From: Contact Centre (CRM) <contact@ribblevalley.gov.uk>
Sent: 19 August 2023 10:53
To: Planning
Subject: Planning Application Comments - 3/2023/0627 FS-Case-540498614

Planning Application Reference No.: 3/2023/0627

Address of Development: 95 King Street
Whalley

Proposed Ground Floor Plan
1:50 Scale

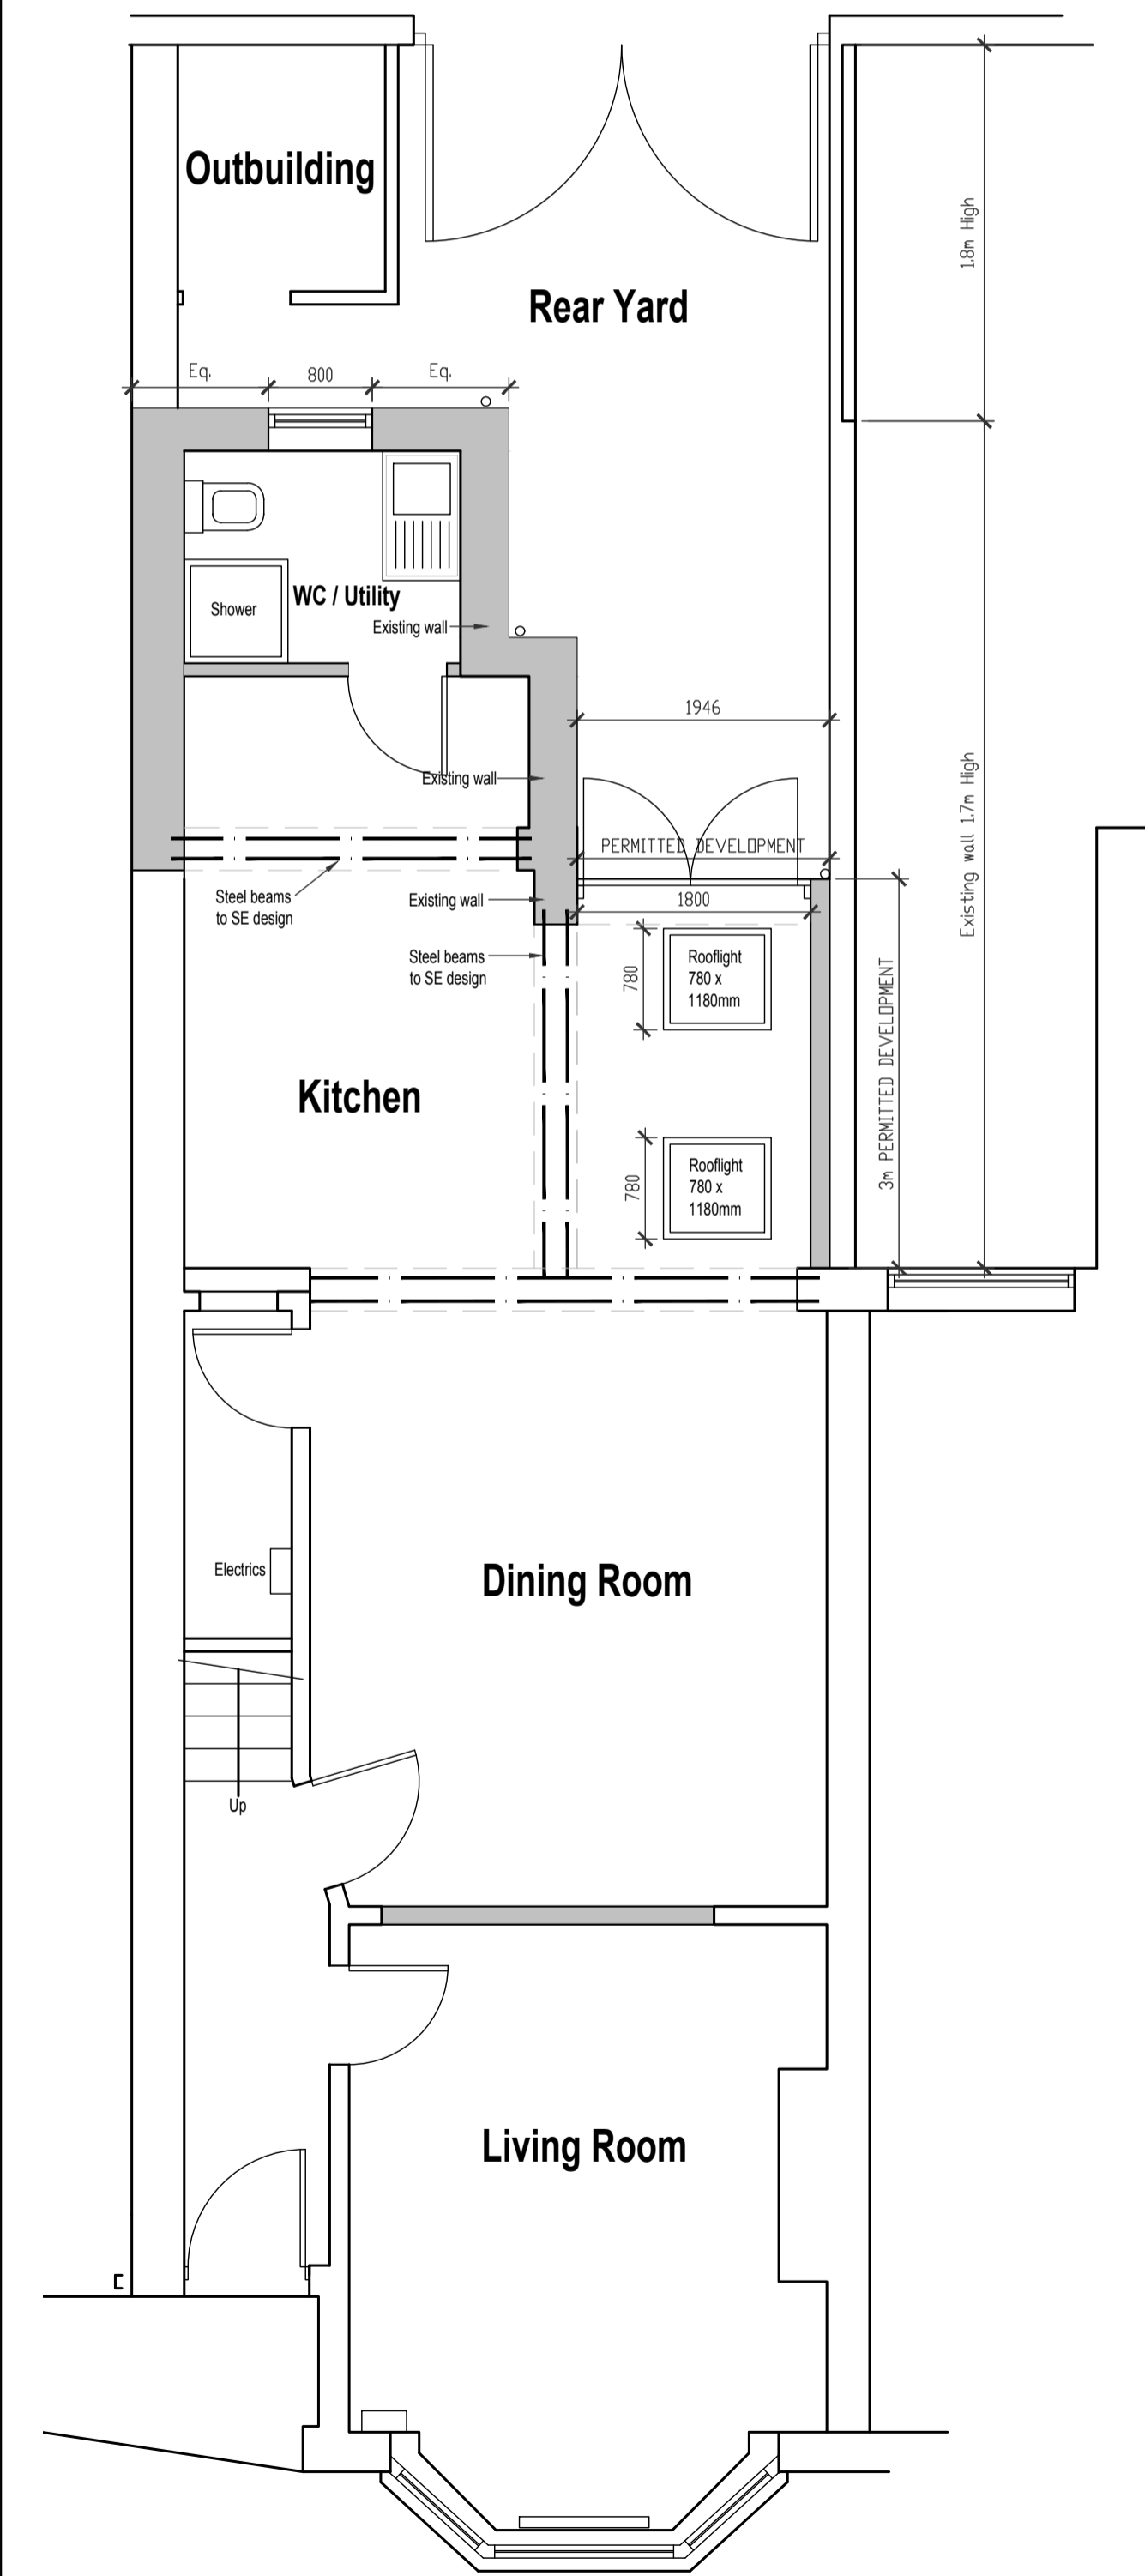
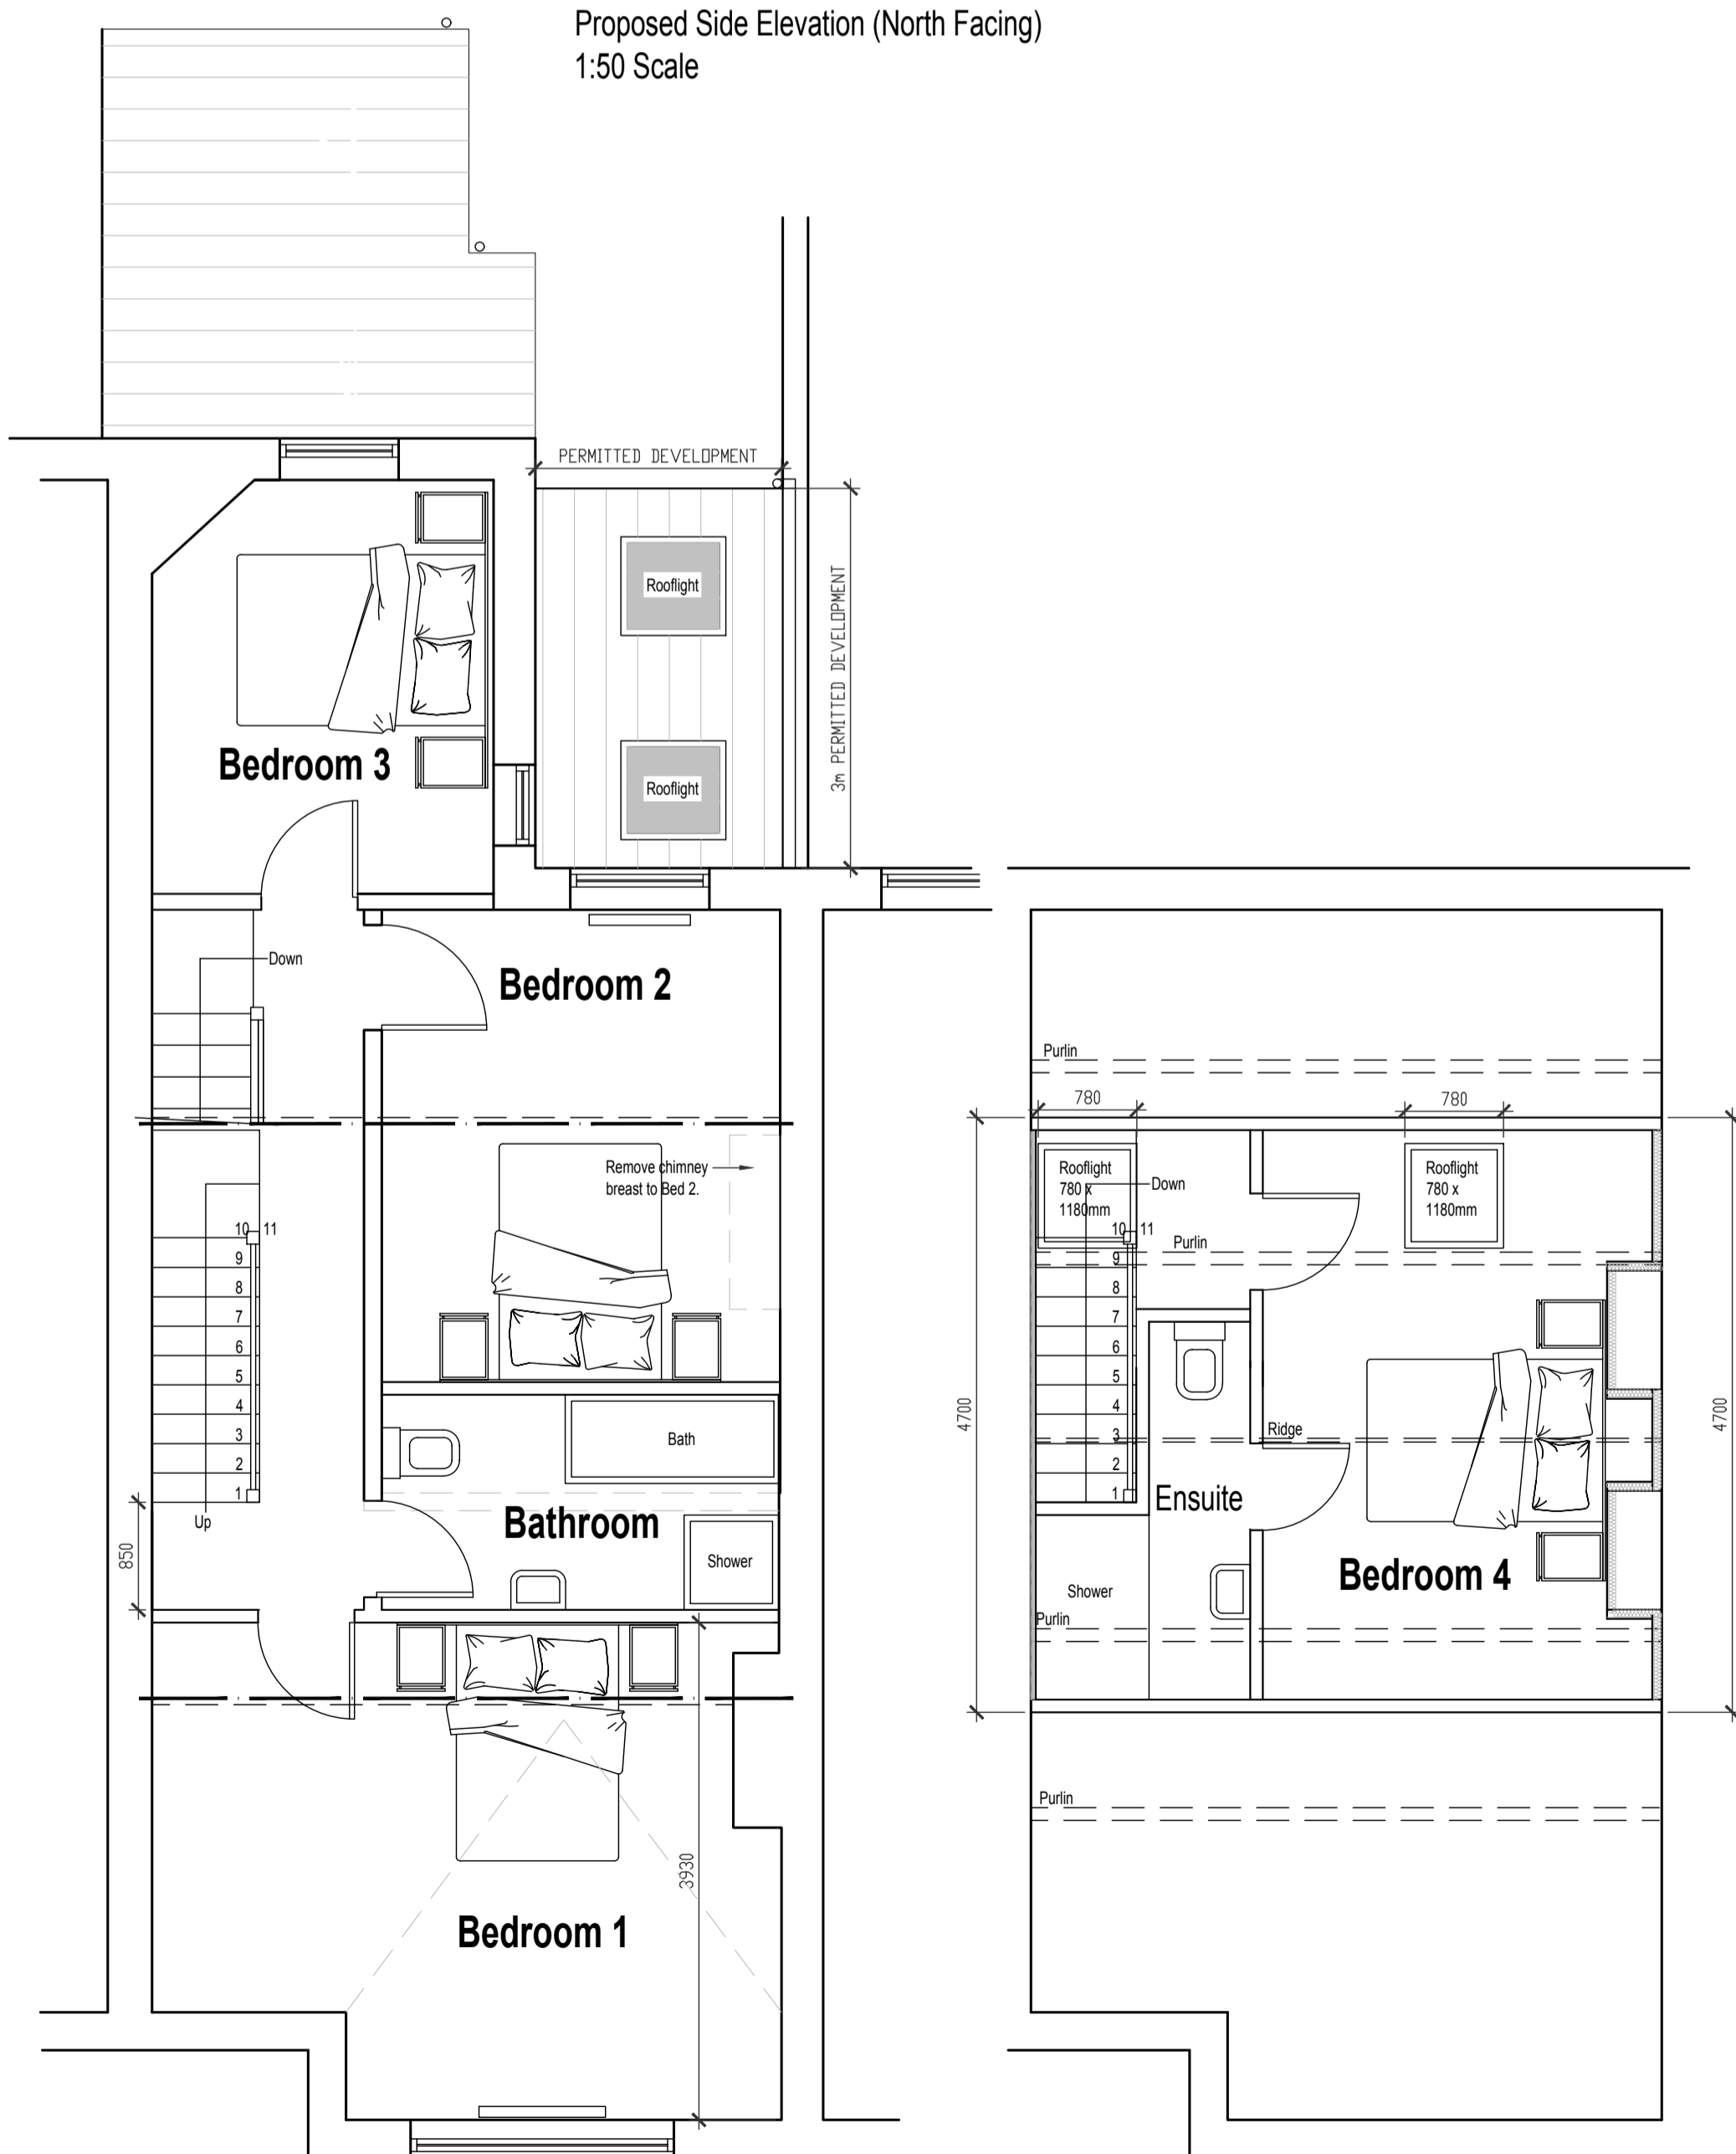
Comments: Concerns regarding existing parking not being available after property development - states on planning a proposed garden not parking. Access to the sheltered accommodation could be significantly affected, access needed for emergency services at all times and any general access for the properties behind and adjacent to the development

Comments: I would like to raise my concern about parking at the rear of 95 King Street . I am under the impression that the owner is going to crest a garden area and this would use the existing parking space . So my concerns are that a 2 bedroomed house is now a 4 bedroomed house with nowhere to park . Parking in the alleyway would cause a blockage for emergency vehicles, and hinder access to [REDACTED]
